Town & Country Planning Act 1990 (as amended)
Town and Country Planning (Development Management Procedure) (England) Order 2015
Application for Planning Permission

Development Construction of a crematorium comprising a crematorium building & associated structures, car parking, access & landscaped spaces. This application is a Departure from the Development Plan.

Location Land south of the A259 Grevatt's Lane Climping

WEST ELEVATION - 1:50

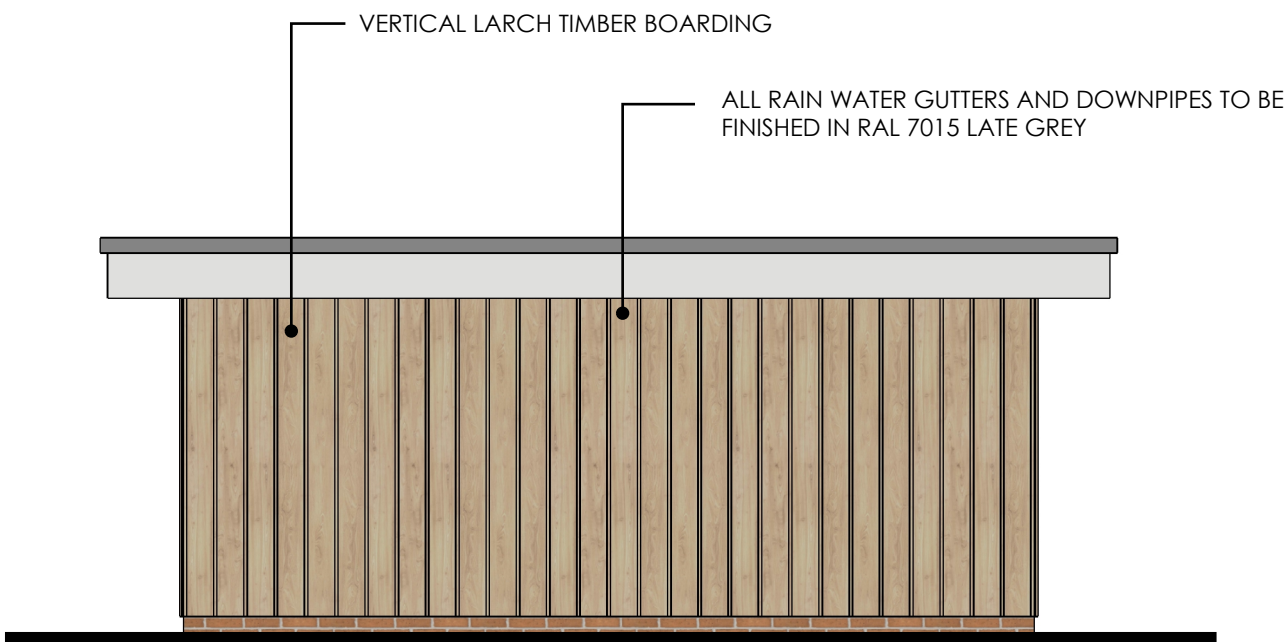
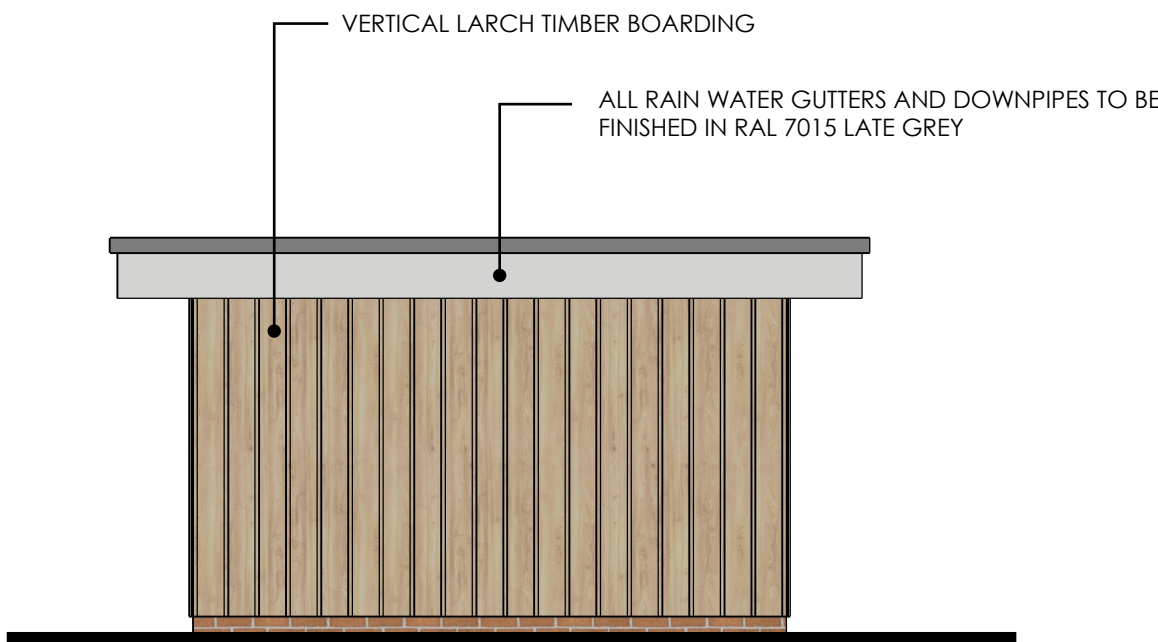
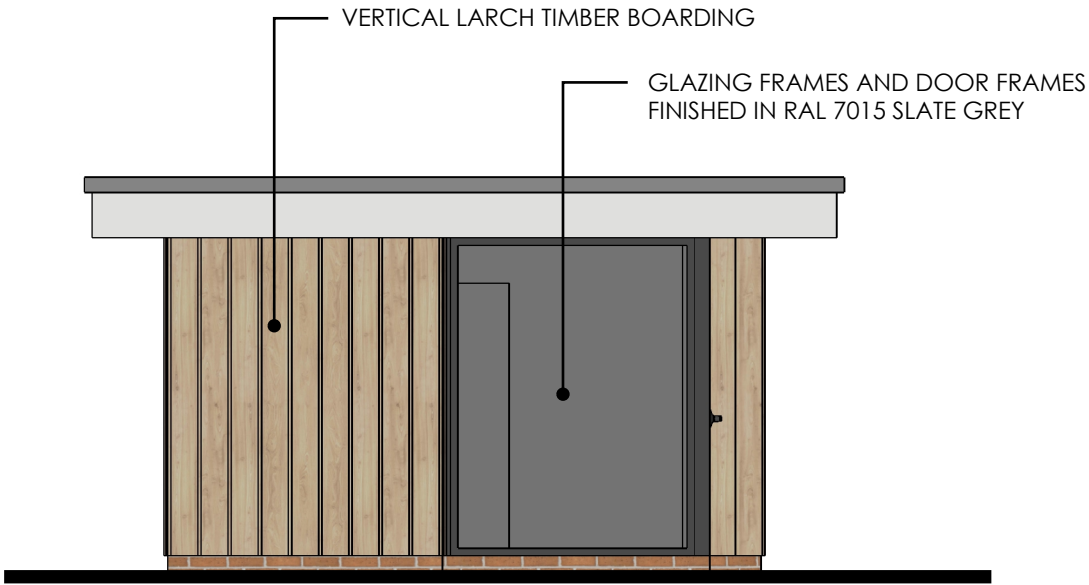
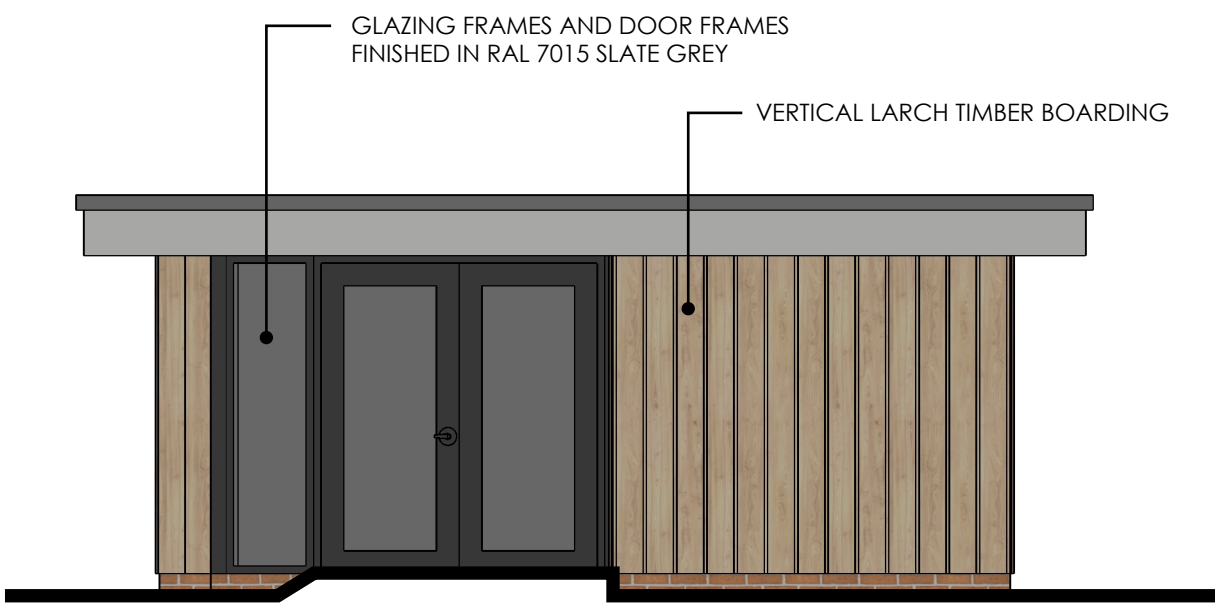
Please show the elevation of the book store on plan SS-CLMPG-V1-DR-K-0504 REV 1ST.

The West elevation and ground floor plan do not accord. Please amend accordingly.

The North elevation seems to have been labelled incorrectly. I suggest this should be the West elevation. Please amend accordingly.
